779 Warren Ave - Permit #2017-01953 for a propane tank

I have completed my initial zoning review for this permit and I need some more information before I can sign off.

779 Warren Ave

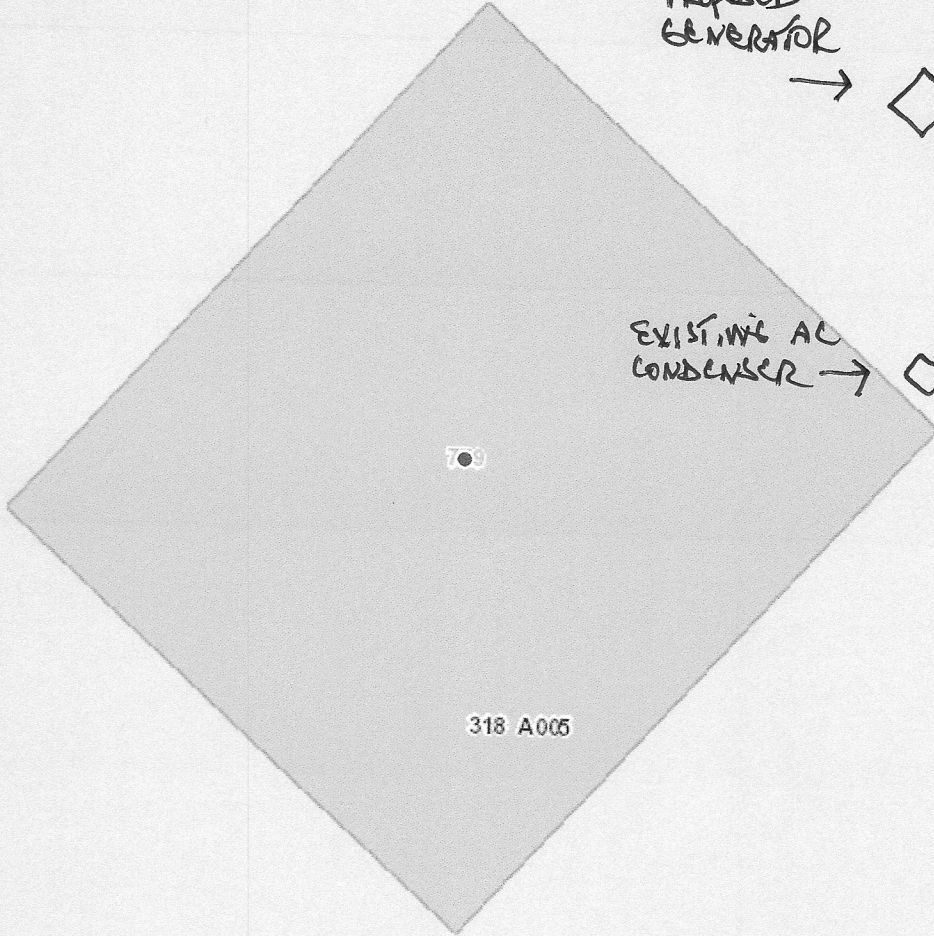
The proposed propane tank location is within the AE flood zone from the Presumpscot River. For any development in the Flood Zone, a two part Flood Development permit application needs to be filled out and submitted to zoning. I have attached the two applications. Please fill out the applicable parts and return them to me. There is no extra fee for the application.

Although this is considered new development, it is a minor permit for a propane tank. Even for minor development, I need to know the following information. I need to know how the tank will be "adequately anchored to prevent flotation... or lateral movement of the structure resulting from hydrodynamic and hydrostatic loads, including the effects of buoyancy". Is the material being used resistant to flood damage? Will it be installed to prevent "water from entering or accumulating within the components during flooding conditions?"

Hello Ann,
Attached please find the additional completed applications as requested. The tank will be tied to a precast concrete pad (4'X12'X6") with a steel cable tie down system.
Thank you.
